From: COMAN Malgy <Malgy.COMAN@rms.nsw.gov.au>
Sent: Monday, 20 February 2017 4:27 PM
To: Kerry Hamann
Subject: 08_0157 MOD 4 - Minto Maltings modification

Our Reference: SYD12/00153/05

DP&E Reference: 08_0157 MOD 4

Roads and Maritime has reviewed the additional information and provide the following comments:

Figure 4-5 Pembroke Rd / Stonny Batter Rd

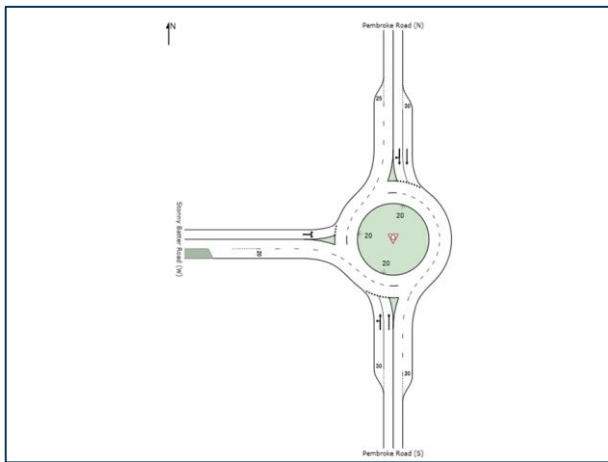
- It is noted that the SIDRA modelling for the proposed increase in import by road suggests that the Stonny Batter Road/Pembroke Road intersection is operating at a level of service A. However, the Department of Planning Assessment report provided in Appendix A of Cardno's response dated 22 November 2016, for the previous modification application (08_0157 MOD1), states that this intersection is already failing during both AM and PM peak hour traffic conditions. It is not clear how an increase in traffic movements will result in an improved level of service at this intersection.

Figure 4-9 TCS No.3373 Phase Diagram

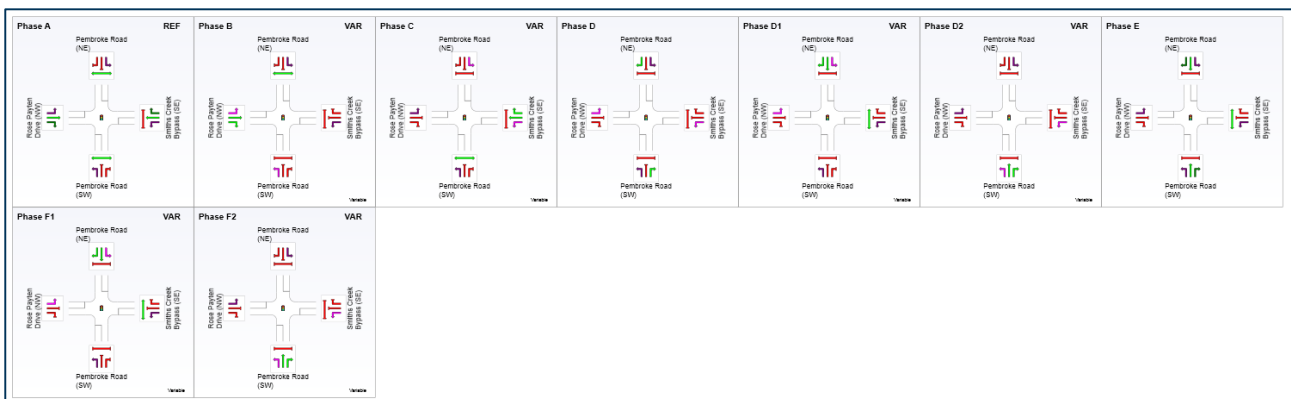
- The 'Practical Cycle Time' option adopted in the SIDRA Model is not supported and the existing cycles times should be used to provide a better indication of existing traffic conditions.
